FORMAL OBJECTION

State Significant Development Application SSD-97528708

160 Oxford Street, Paddington

Re: SSD-97528708 — Mixed Use Development with Infill Affordable Housing, 160 Oxford Street, Paddington

Figure 4.5
Overshadowing diagram showing the impact at 9am on 21 June
Source: Smart Design Studio

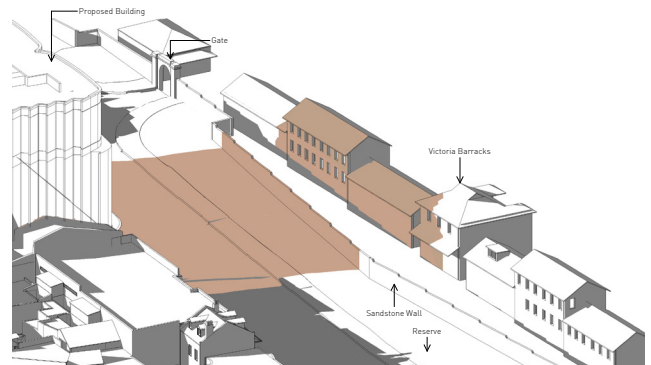
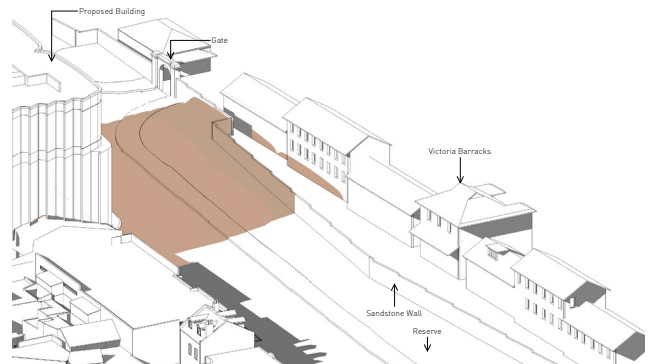
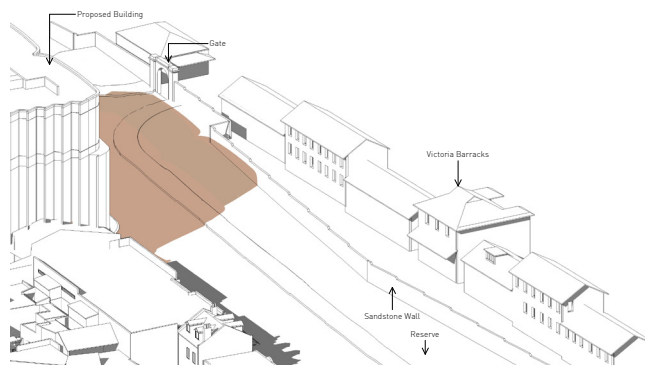
The shadow diagrams should be examined to determine the hours of overshadowing imposed on the heritage cottages on Gipps Street and Shadforth Street at the winter solstice (21 June). The ADG requires at least 2 hours of direct solar access to principal living areas of adjoining dwellings between 9am and 3pm. The HIS itself acknowledges (Section 4.3.12) that “the proposal will overshadow part of the Barracks in the mornings of the winter months” and will “overshadow the rear parts of Buildings 95 and 96 for a few hours.” The impact on the residential properties to the north — which are far closer than Victoria Barracks — warrants careful scrutiny.

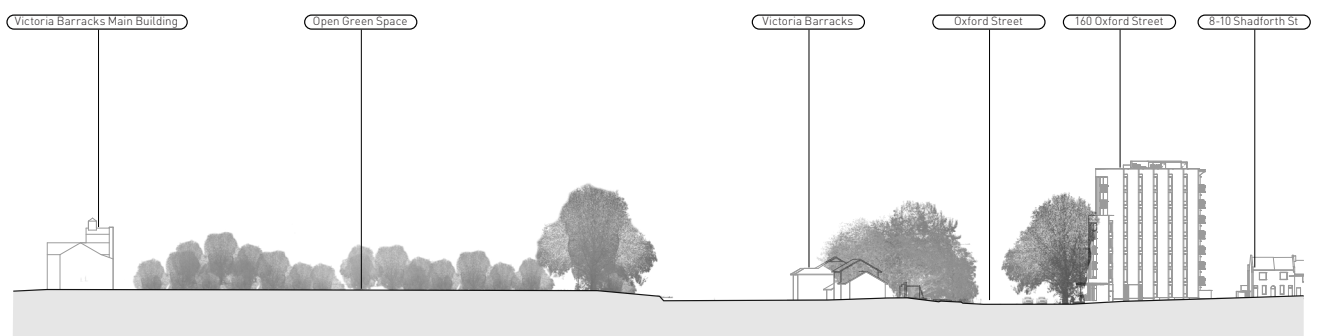
(c) The Victoria Barracks assessment. The HIS acknowledges (Section 4.3.2) that the heritage assessment of Victoria Barracks identifies “views to the Paddington township” as having heritage significance. It then concludes the impact is “acceptable” partly because “Block F of the University of NSW Art & Design School... is already visible from within the Barracks.” This is a “two wrongs make a right” argument: the existence of one intrusive element in a heritage setting does not justify adding another. The HIS also relies heavily on mature Oxford Street trees to “obscure views of the lower 5 stories” (Section 5.2). Tree canopies are seasonal and not permanent — and the upper 3 storeys (the bonus storeys) will be clearly visible above the tree line in perpetuity.
